Alan Cadogan - MP 09_0066 MOD 6 - Chatswood Albert Ave/Thomas St Development Concerns

From: "Loveday, Mike, Vodafone Group" <mike.loveday@vodafone.com>
To: <alan.cadogan@planning.nsw.gov.au>
Date: 2/05/2013 4:45 PM
Subject: MP 09_0066 MOD 6 - Chatswood Albert Ave/Thomas St Development Concerns

SHADOW DIAGRAM
21 SEPT

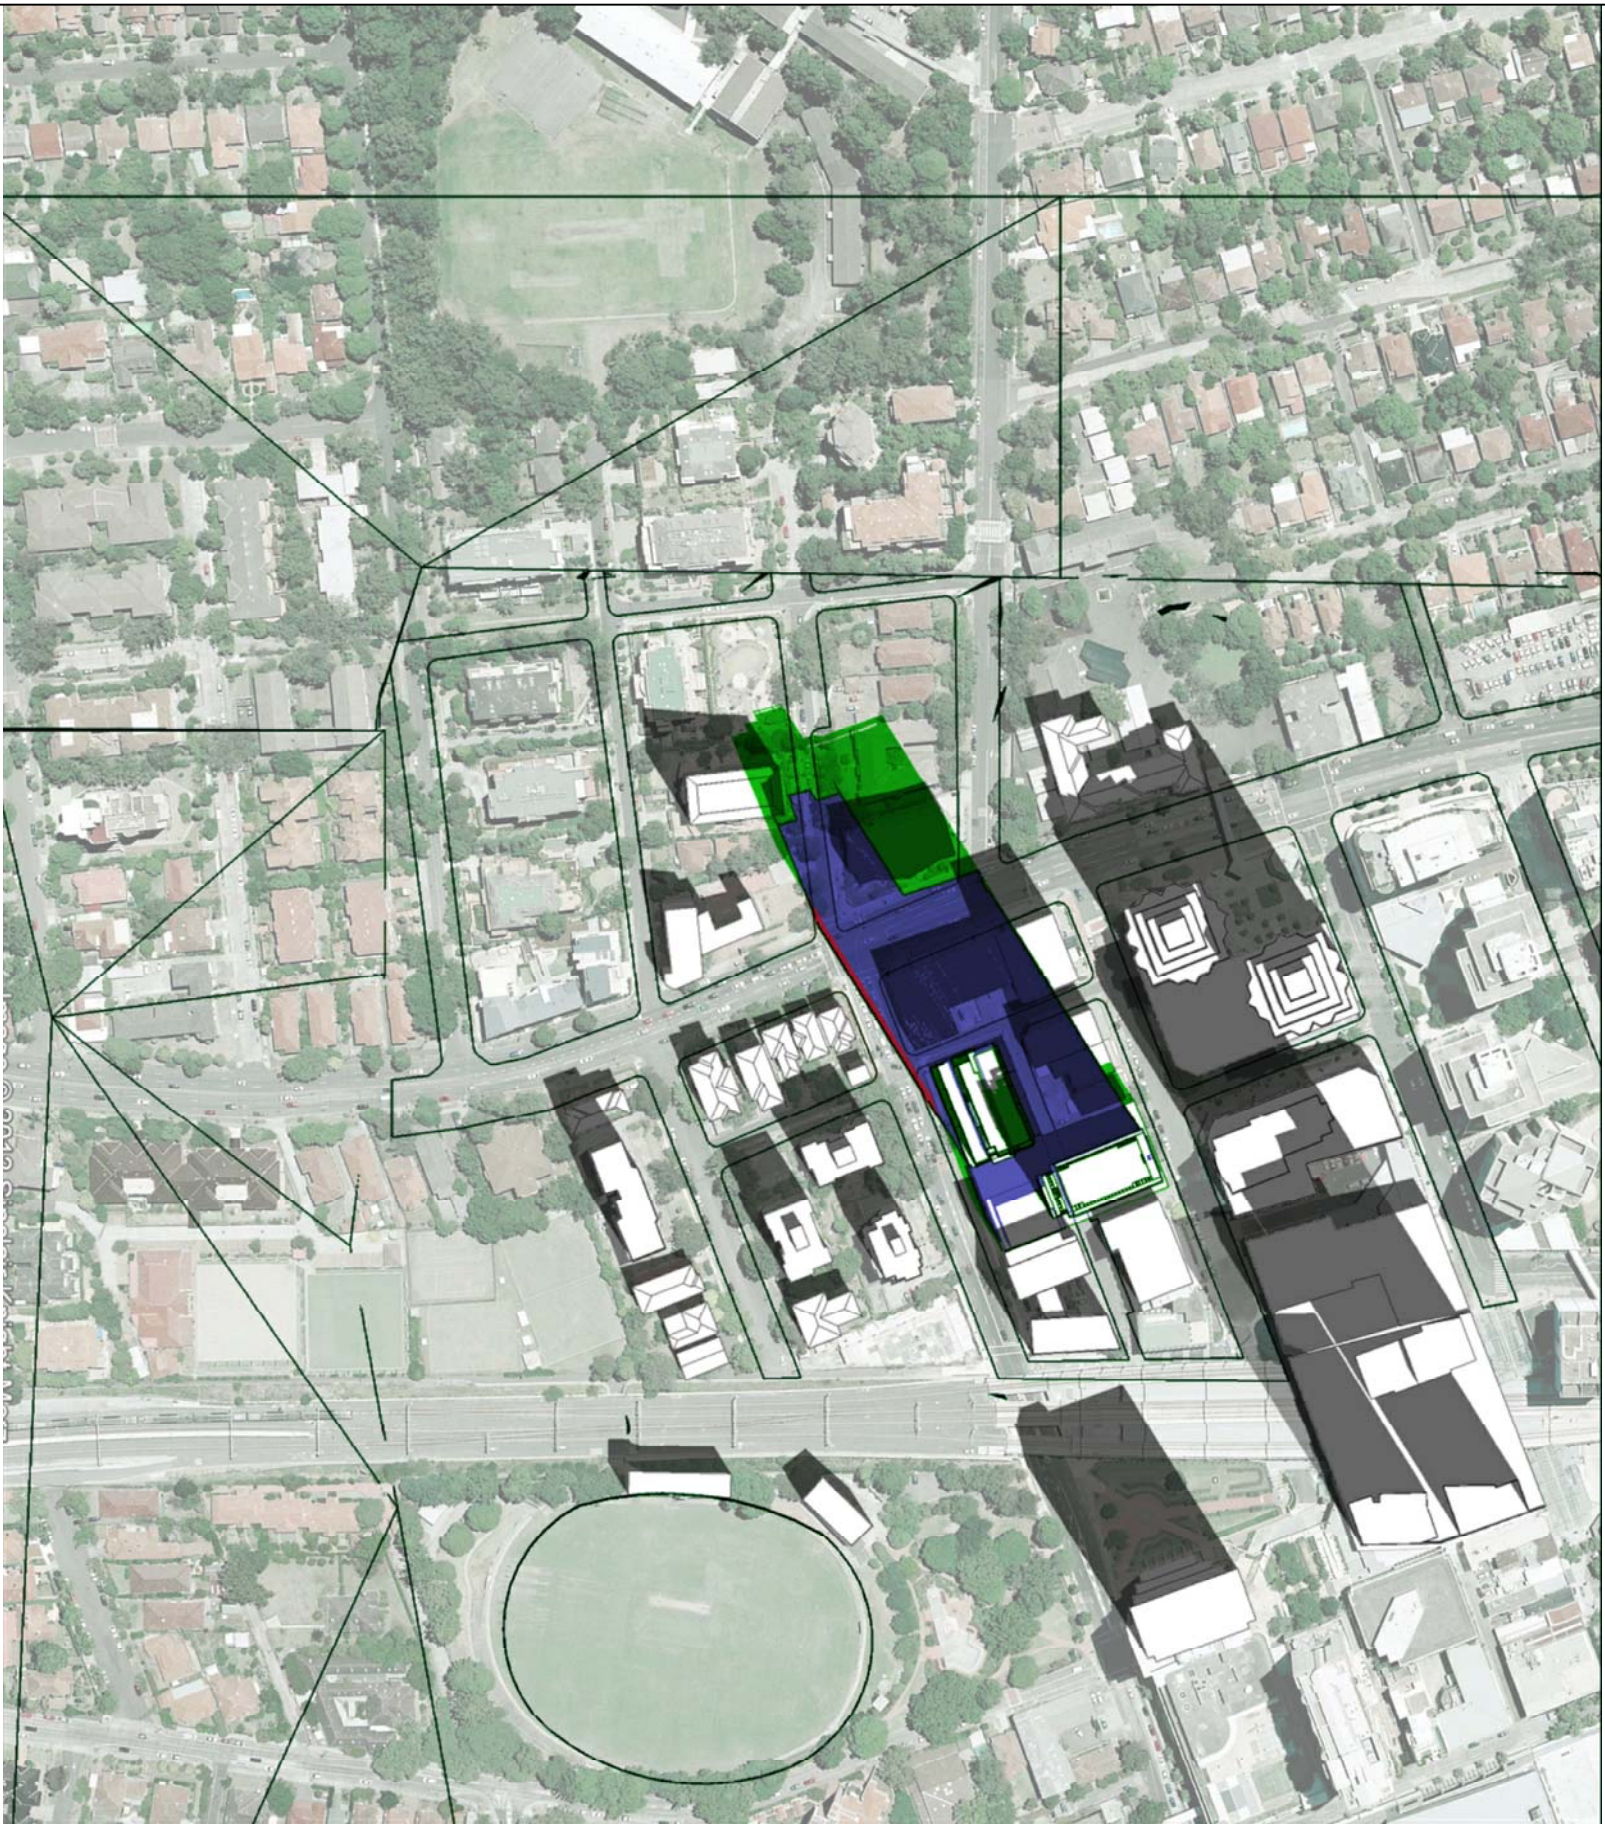
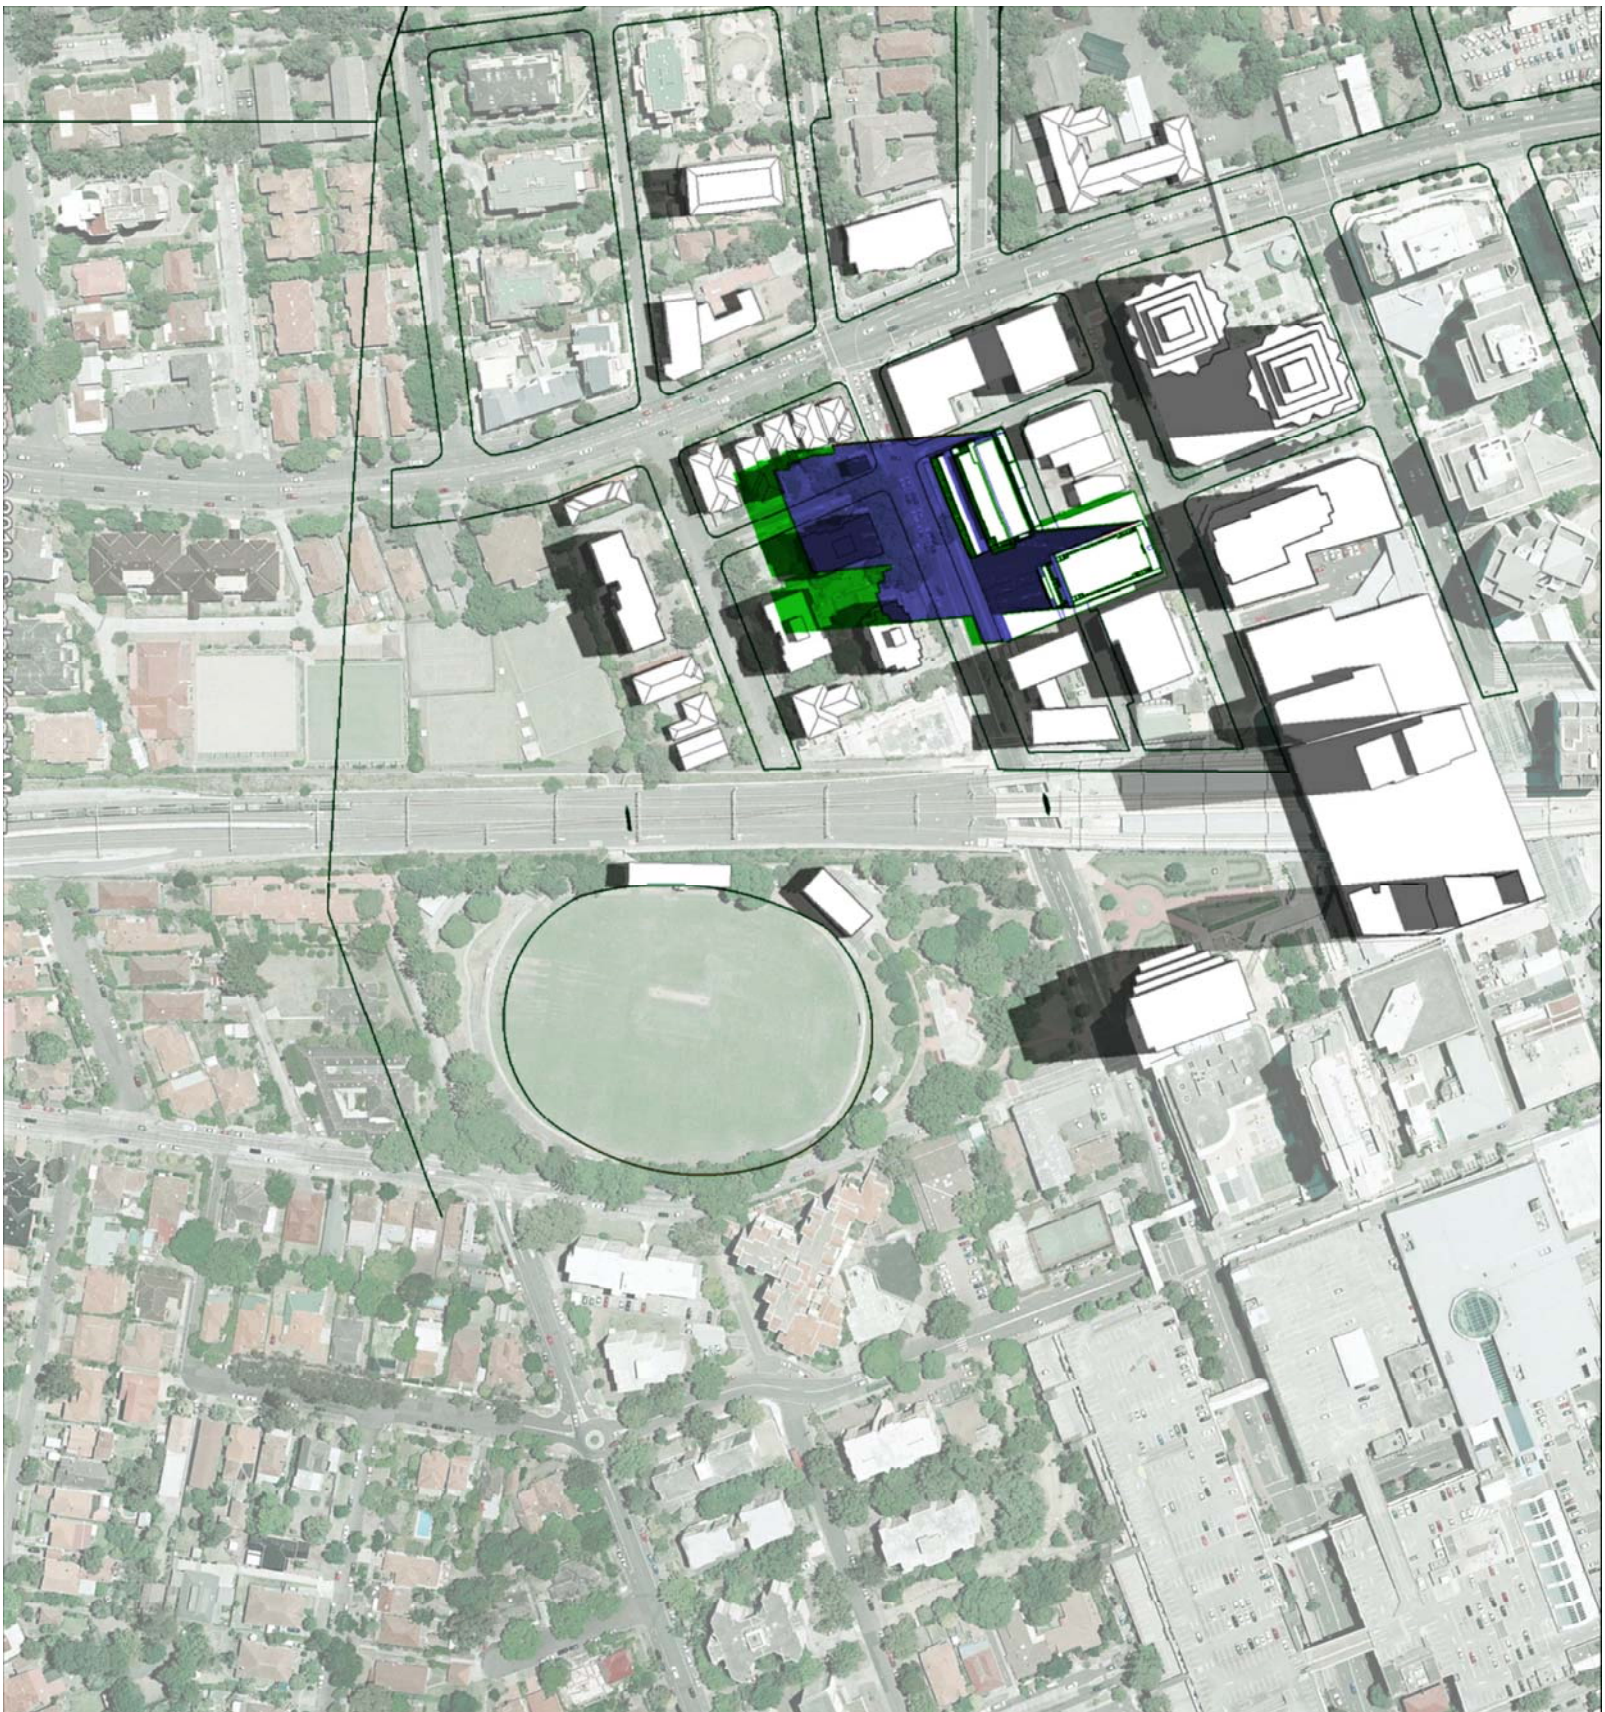
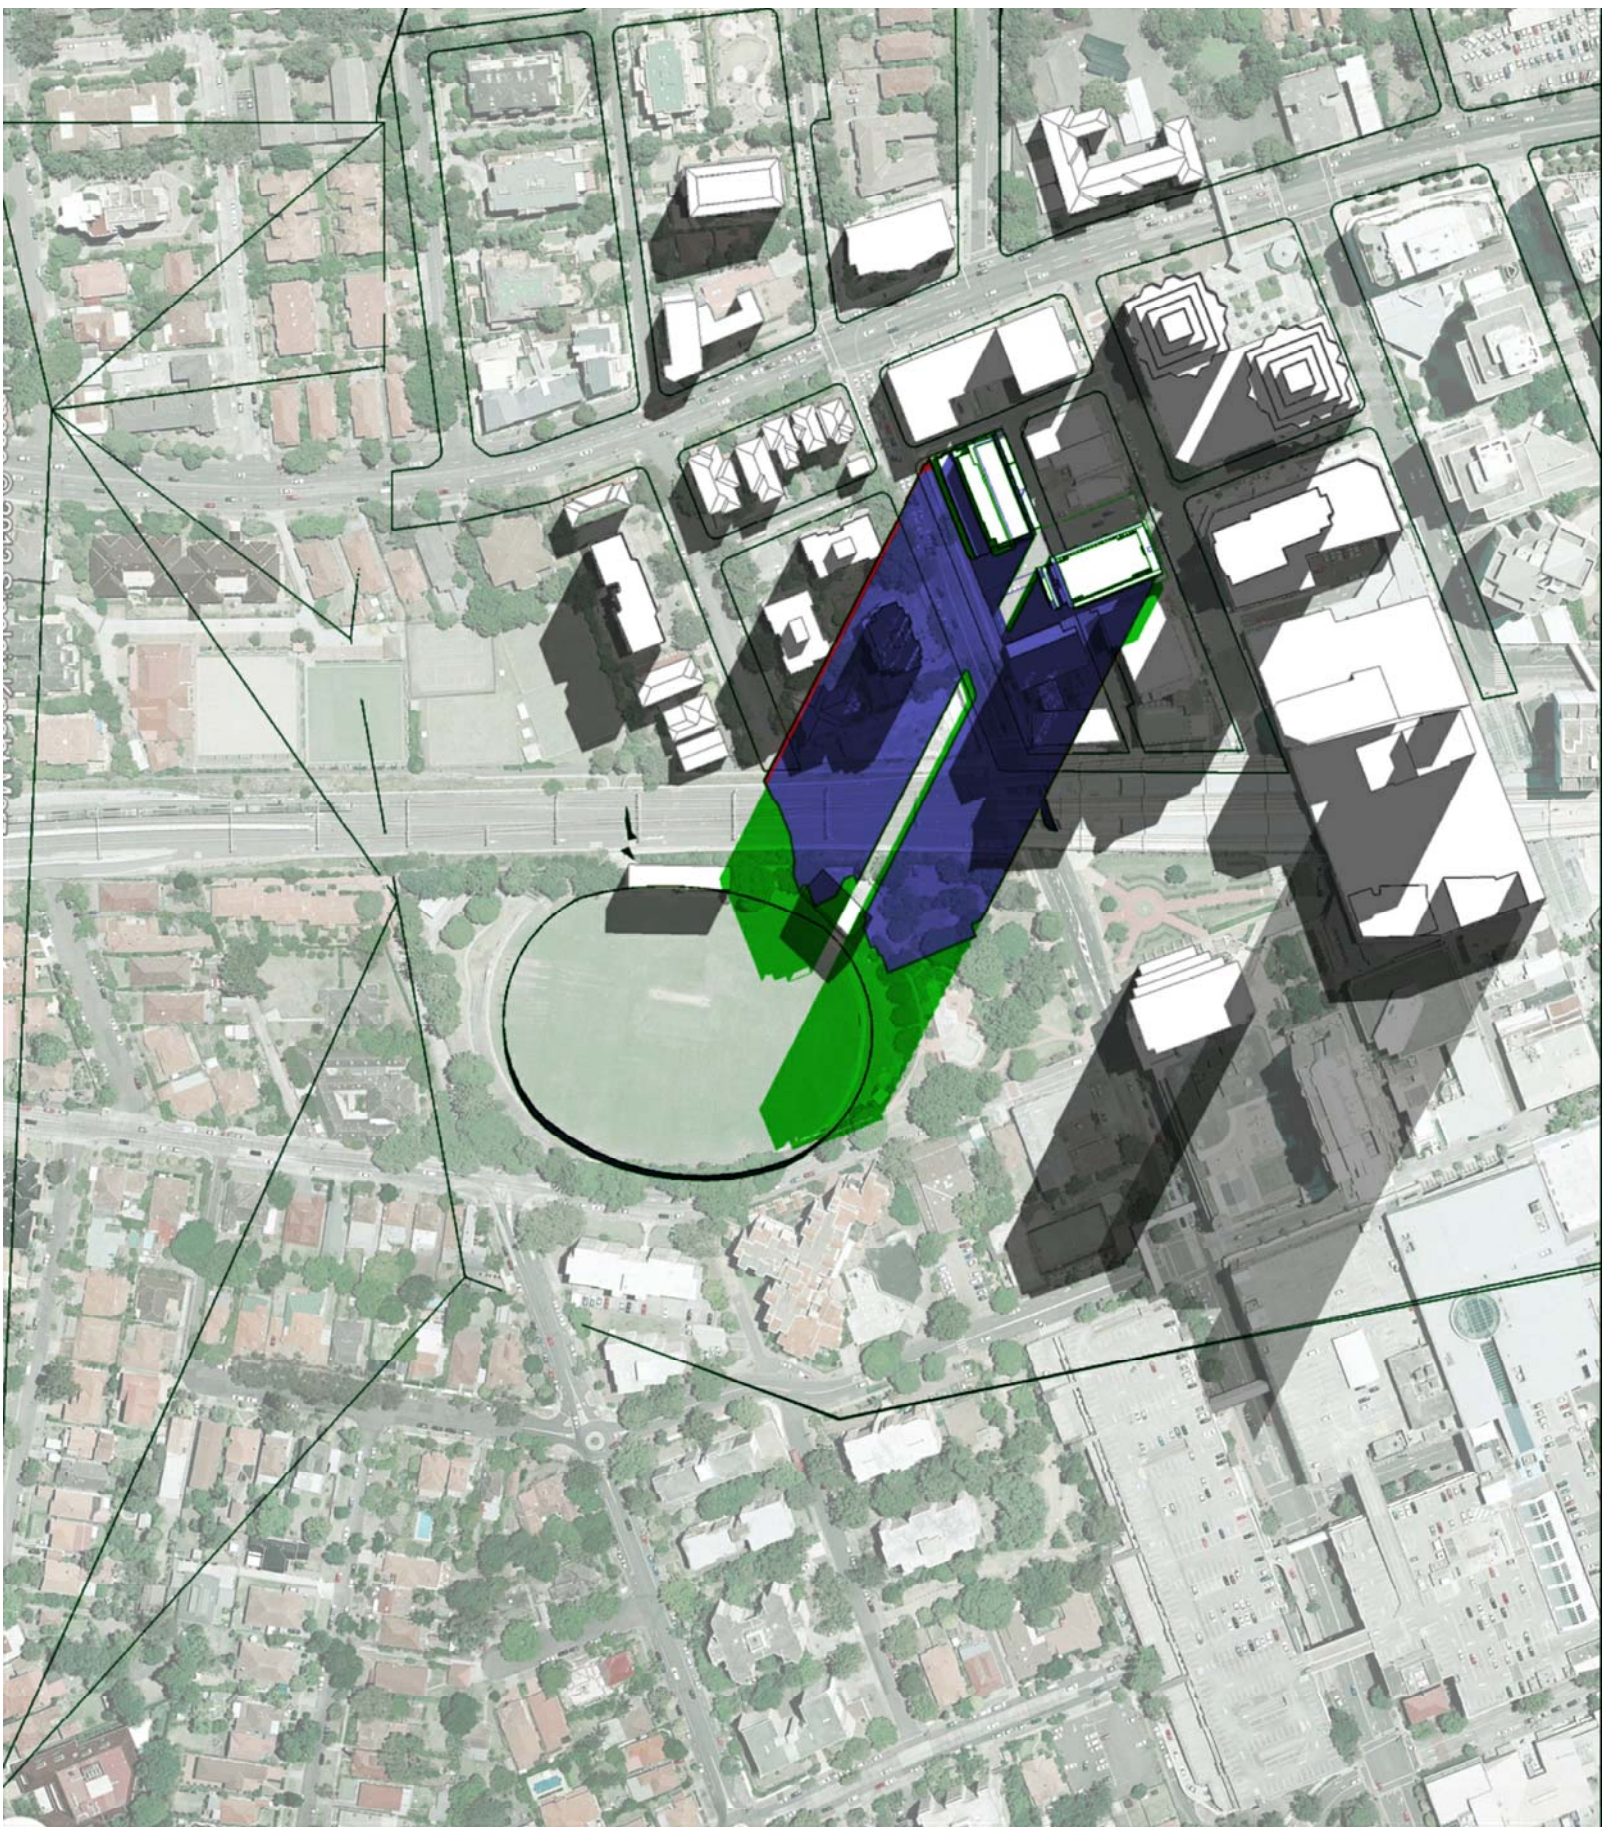
Massing Impact from the bulk form of Tower-2 as well as loss of solar access and shadowing will be further excessive given that this tower is longways across the site. Being a north facing rectangular bulk form, it will shadow the much smaller residential fringe to the south including the nationally prized Chatswood Croquet and Bowling Greens and Chatswood Oval.
